**Application by Highways England for M54 to M6 Link Road**  
**The Examining Authority's written questions and requests for information (ExQ1)**  
**Issued on 20 July 2020**  
**Responses From: Allow Ltd**

FIGURE 2.6
DRAFT ENVIRONMENTAL
MASTERPLAN
SHEET 4 OF 5

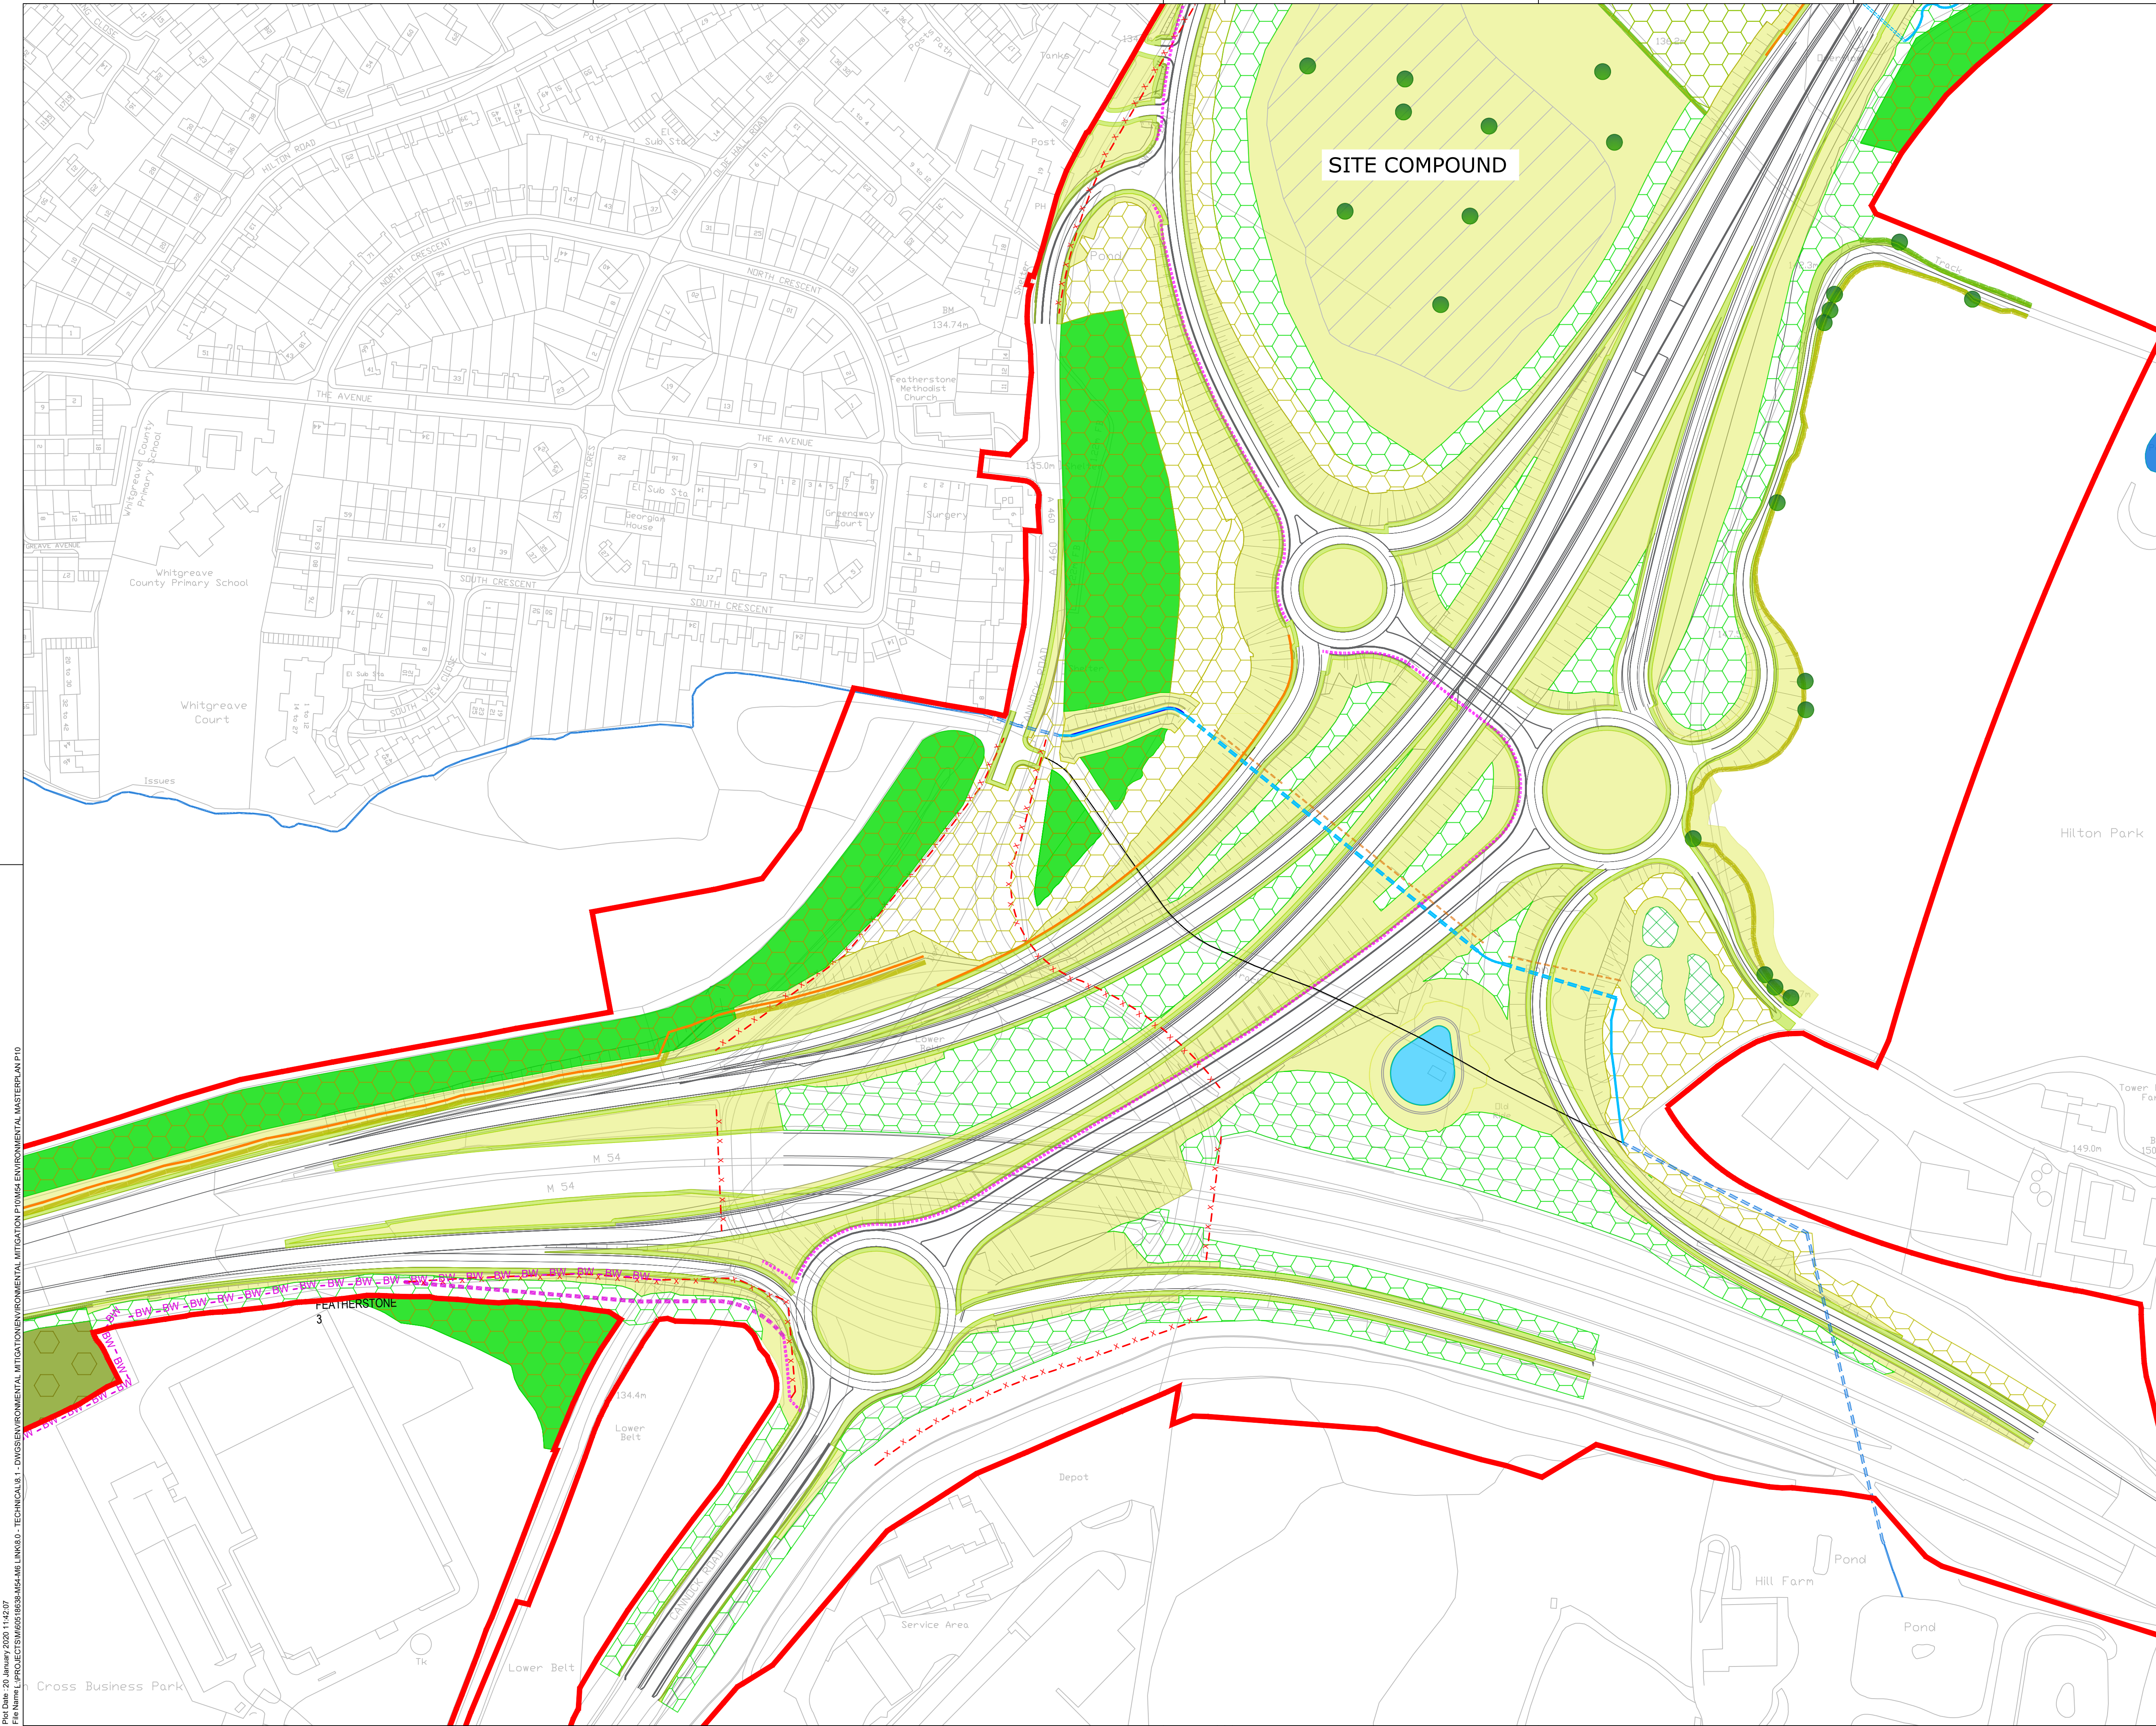
1.2.4 A total of 3.26ha (as updated 21.08.20) of Allow Ltd.'s land is proposed to be taken by the scheme works and a further 8.24ha (as updated 21.08.20) of additional land for environmental mitigation, the majority of which is for new planting. It is considered that this is excessive in terms of replacing those trees lost in the locality, being several times the area taken.

1.2.5 A disproportionate area of the replacement planting is proposed to be on Allow's land compared to other parts of the scheme.

- 1.2.6 **It is our opinion that the assessment of woodland taken for works across the scheme has been incorrectly assessed and therefore the area required for mitigation is flawed and overstated. Plans provided by the Applicant to Allow Ltd, which informed the mitigation requirement calculations, illustrate excessive estimates which are clearly not currently woodland on the ground.** These include significant areas of mown grass verges, gorse scrub and brambles. Following our own mapping exercise, it is our assessment that a figure of approximately half the suggested area is a more accurate assessment of the woodland present on the ground. An example would be the central area of the current M54 road island which currently according to OS data and aerial photography have an area of 1.46 ha (3.60 acres) of woodland present, however the area assessed as woodland for the baseline data incorrectly assesses it as 2.391 Ha (5.908 Acres). This is a total of 2.31 acres, or 39%, of incorrectly designated woodland within the road island alone. Further information can be provided if required by the ExA. The extent of the proposed woodland planting will therefore significantly impact upon the openness of the green belt across the area of the scheme due to the area being significantly greater than that area actually taken by the scheme.

- 1.2.7 Widespread planting is not beneficial for the landscape and the proposals will significantly impact upon and change the character of the landscape. An open grassland field of 10.69 ha, (26.42 ac) surrounded by a tree belt which formed part of the original Hilton Park design is proposed to be taken for blanket tree planting. The area of mitigation planting has been reduced by approximately 3.87ha in the revision in August 2020, where the North West corner has been removed from the proposal. The amended proposal will still reduce the openness of the landscape around the Dark Lane, Hilton Lane and A460 junction. But more importantly the historical tree belt, which forms one of many of the original tree belts which were landscaped around the perimeter of the Hilton Park Estate will be lost forever as it becomes obscured in the proposed adjoining new planting – a significant detriment to the local landscape. The rectangle now removed from the proposal does little to reduce the impact upon the historic landscape.

- 1.2.10 There is no indication that adequate consideration has been given to provision of the required environmental mitigation on other land adjacent or close to the scheme. Some additional woodland could be established to the east of the new road in this area by thickening up the existing tree belts east of the Lower Pool, whilst still maintaining open parkland between the house and the woodland. There should also have been some consideration of keeping the proposed woodland planting within plot 5/4 in the eastern part of the plot (adjacent to the new road) therefore allowing the western perimeter tree belt to retain its separate identity.
